TECHNICAL NOTE

CHANDLERS BMW, ANGMERING, WEST SUSSEX

Ref: LAHL/18/4619s

TO:	Arun District Council FAO: Mr A Wood
FROM:	WSCC - Highways Authority
DATE:	14 May 2019
LOCATION:	Chandlers Garage Bmw House Water Lane Littlehampton BN16 4EH
SUBJECT:	A/45/19/PL Demolition of existing buildings (car show room, workshops and Phares Courtledge) and erection of 19 dwellings, a convenience store, a community building, public toilets and associated car parking and landscaping - This application affects the character and appearance of the Angmering Conservation Area.
DATE OF SITE VISIT:	
RECOMMENDATION:	More Information

Scale	1:250	Drawn By	SMO	Checked By	ALB	Approved By	PMR
Date	March 2019	Drawing No	2018-4619-001	Rev.			C

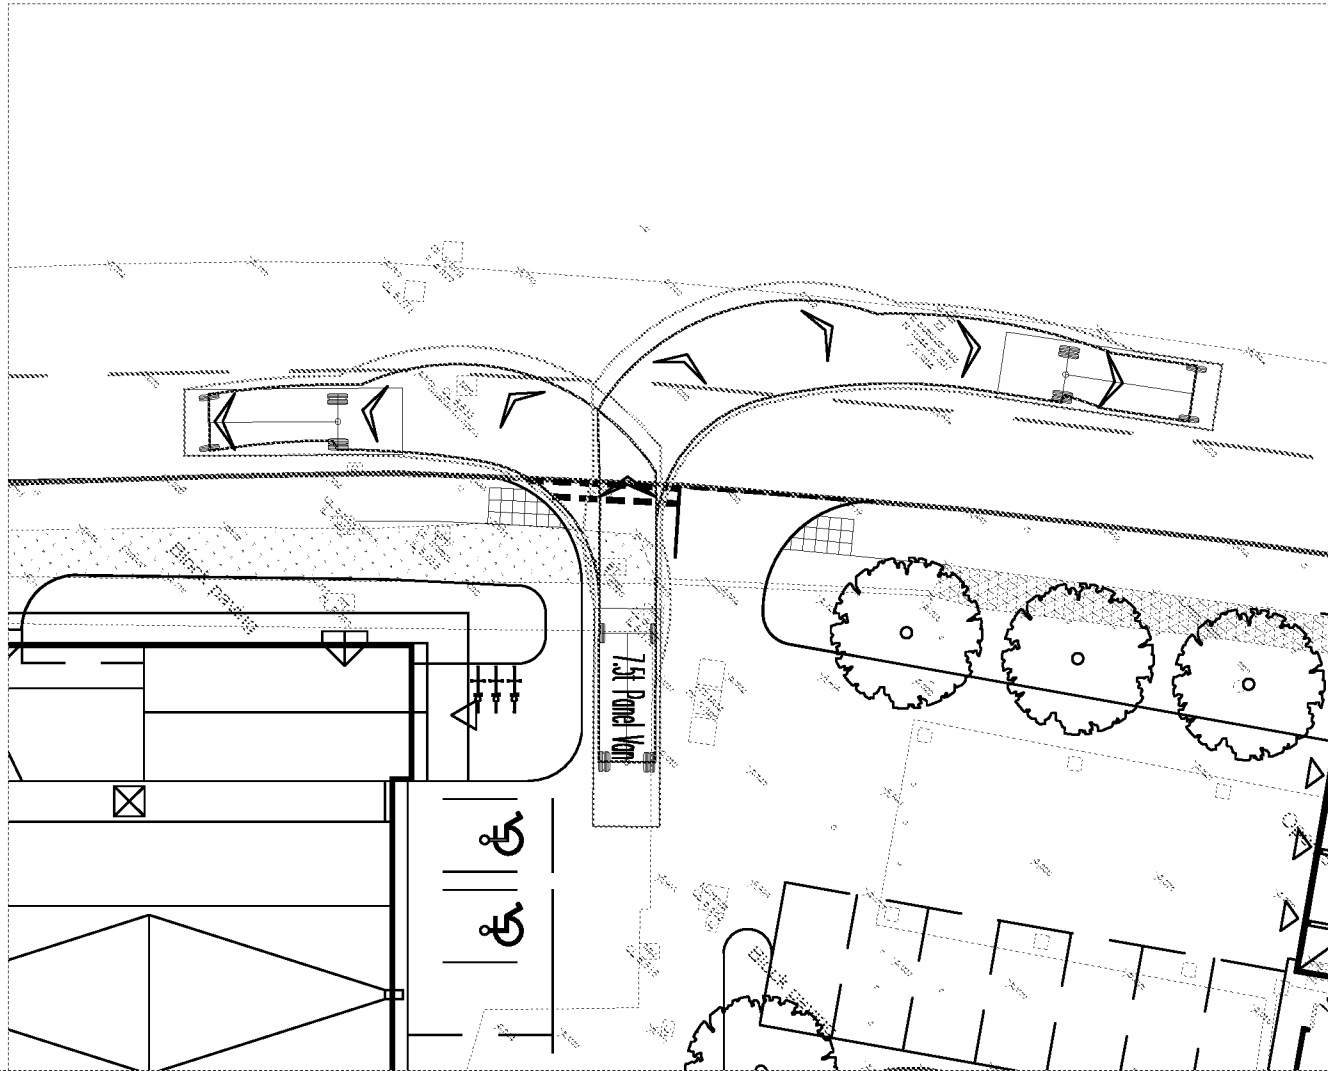
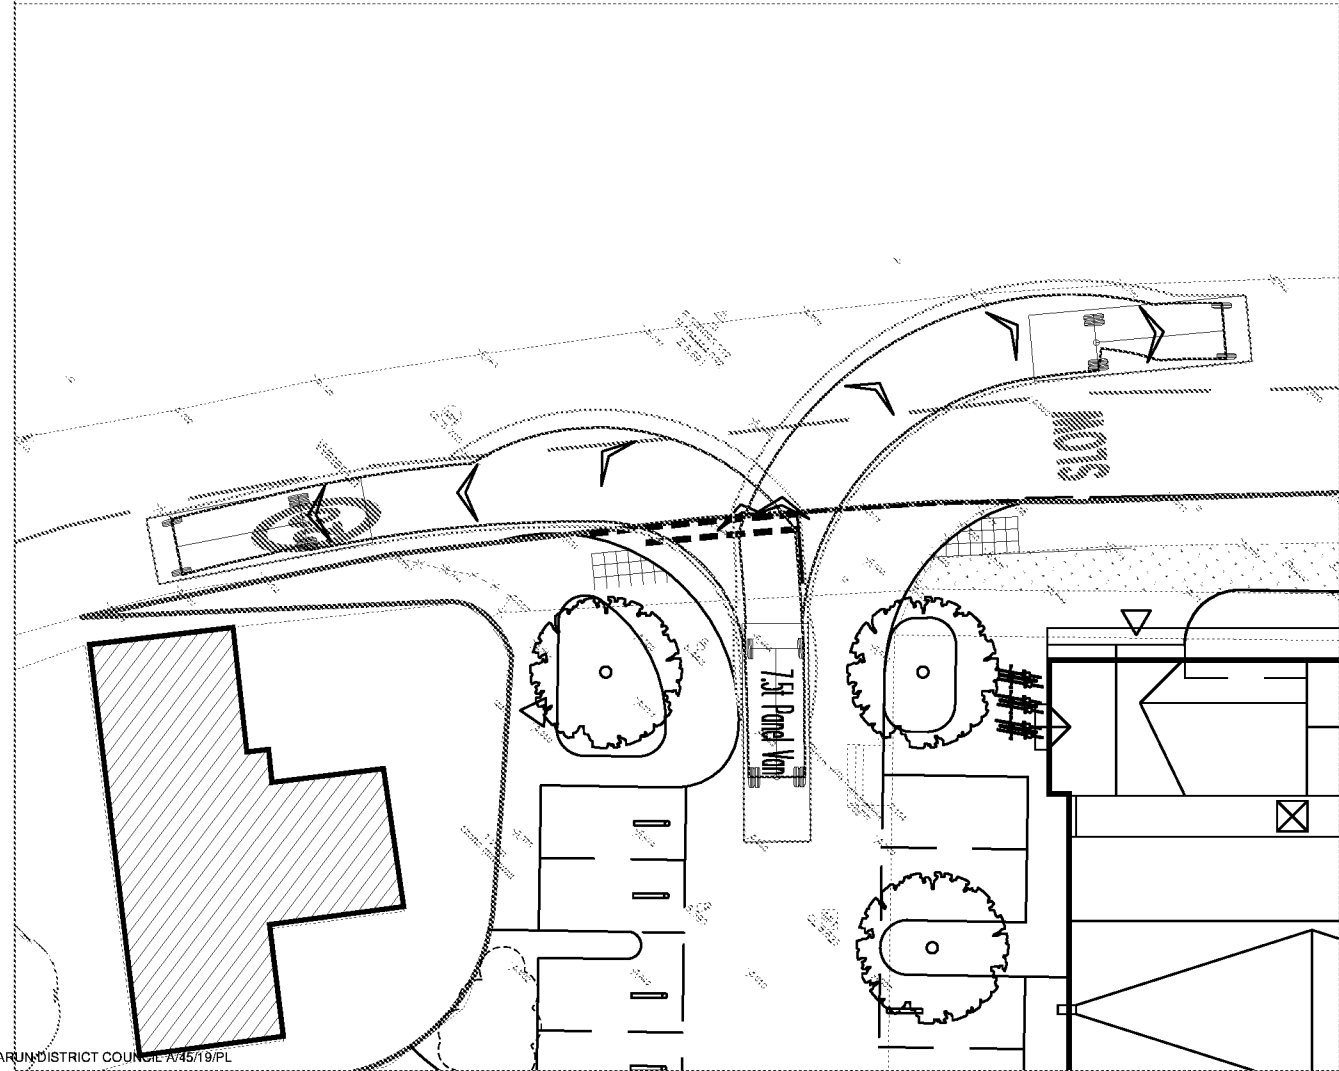
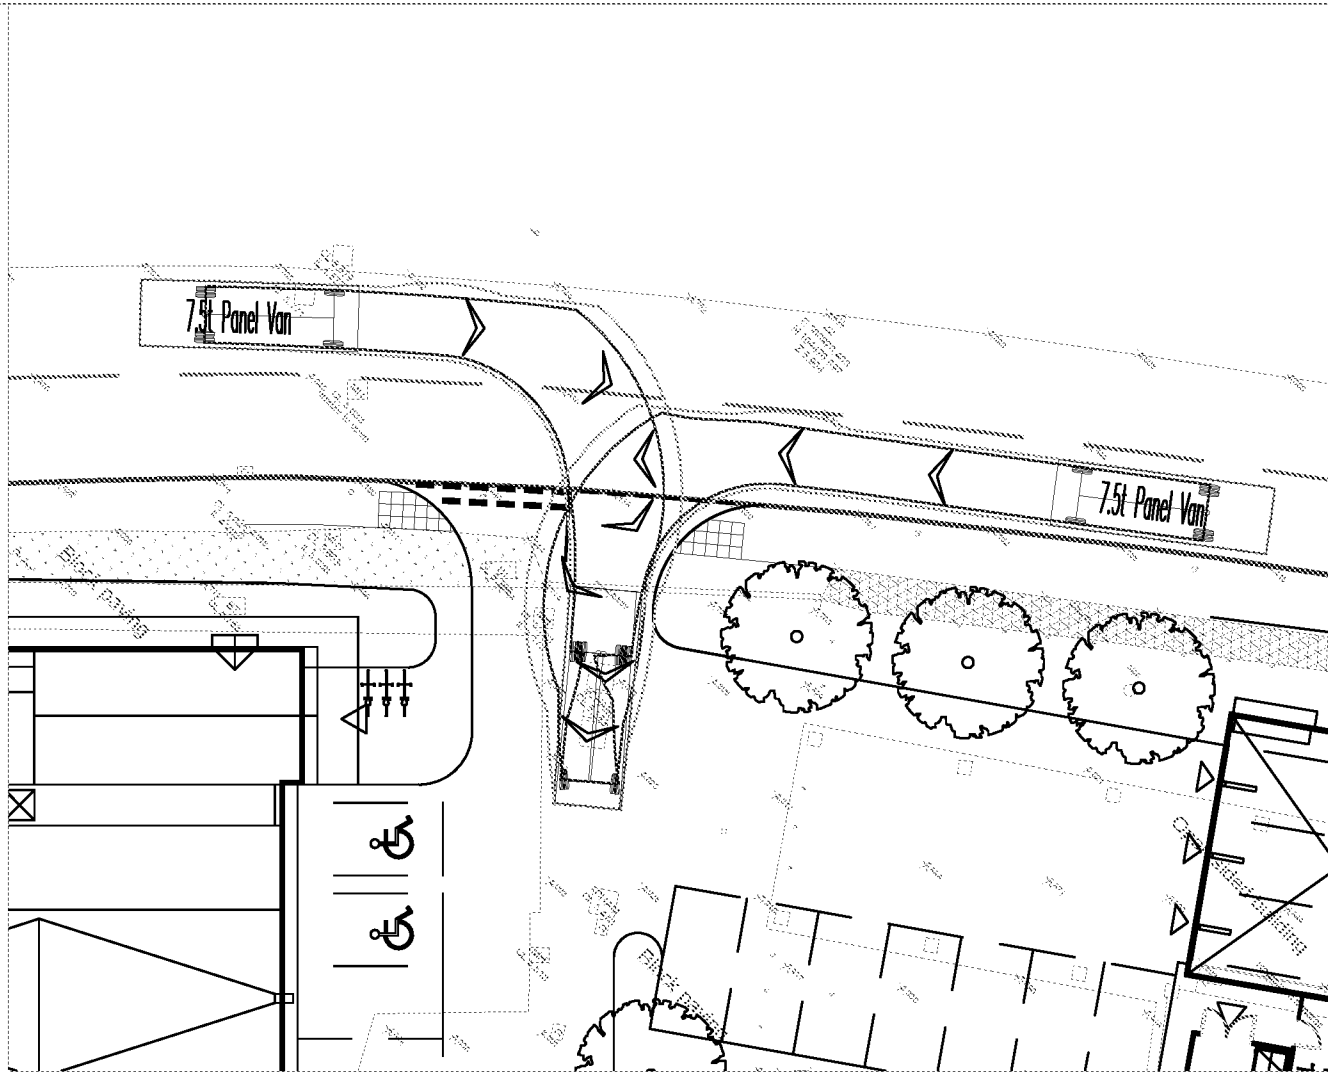
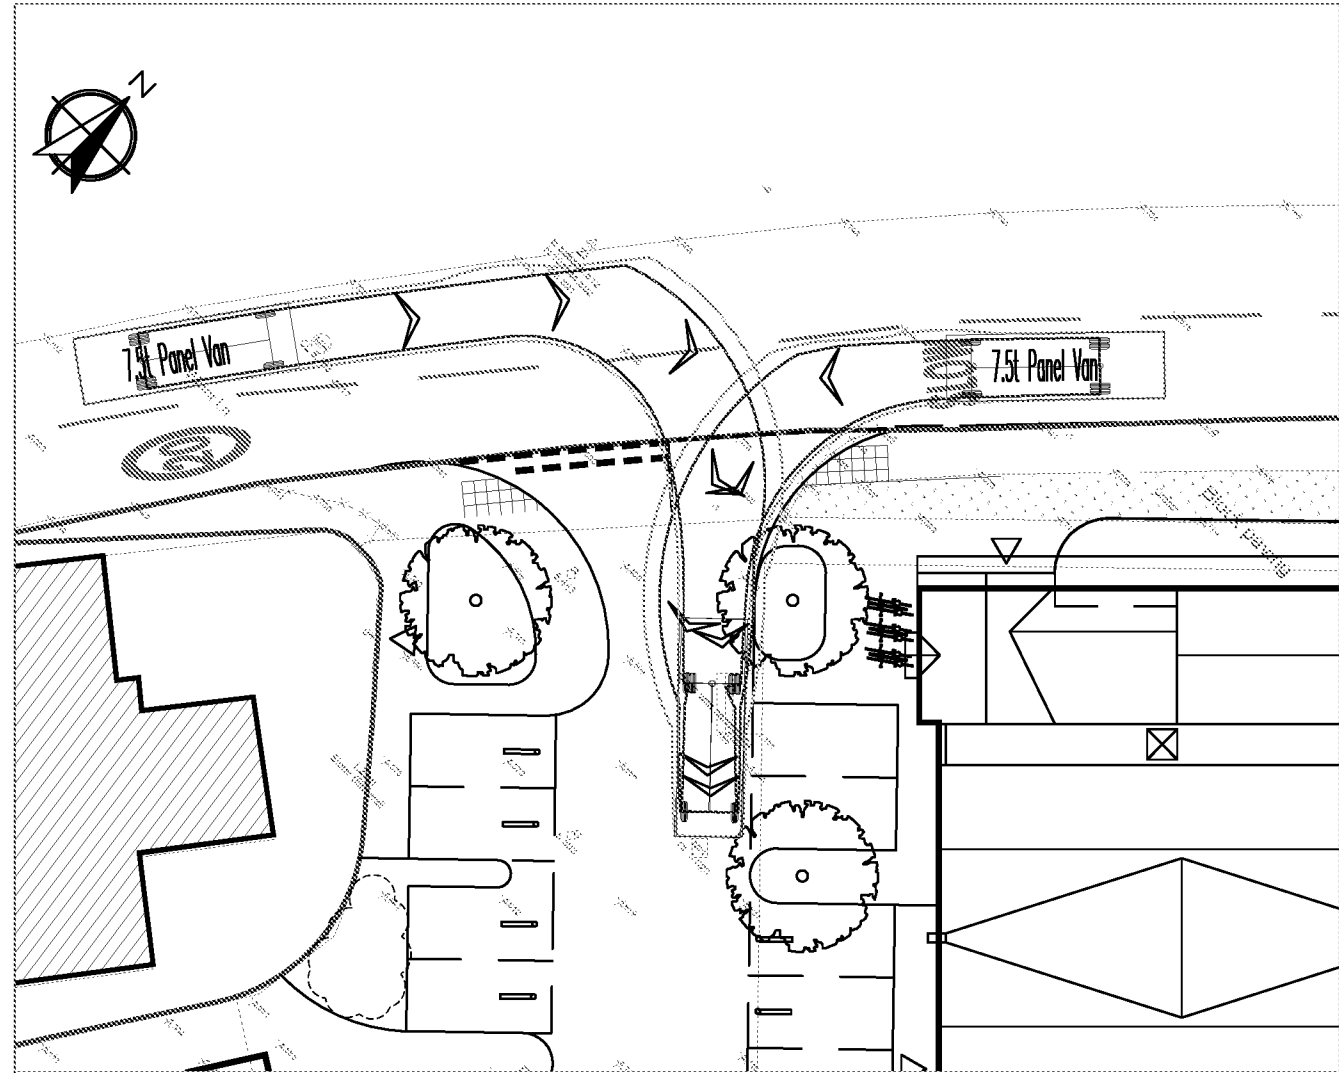
"From observation of the visibility plays provided, it appears the plan outlines a 30mph posted limit within the data box and then contradicts this with 20mph road markings. This should be amended."

From observation of the visibility splays provided, it appears the plan outlines a 30mph posted limit within the data box and then contradicts this with 20mph road markings. This should be amended.

The data box has been updated to show 20mph speed limit on **Drawing 2018/4619/001**.
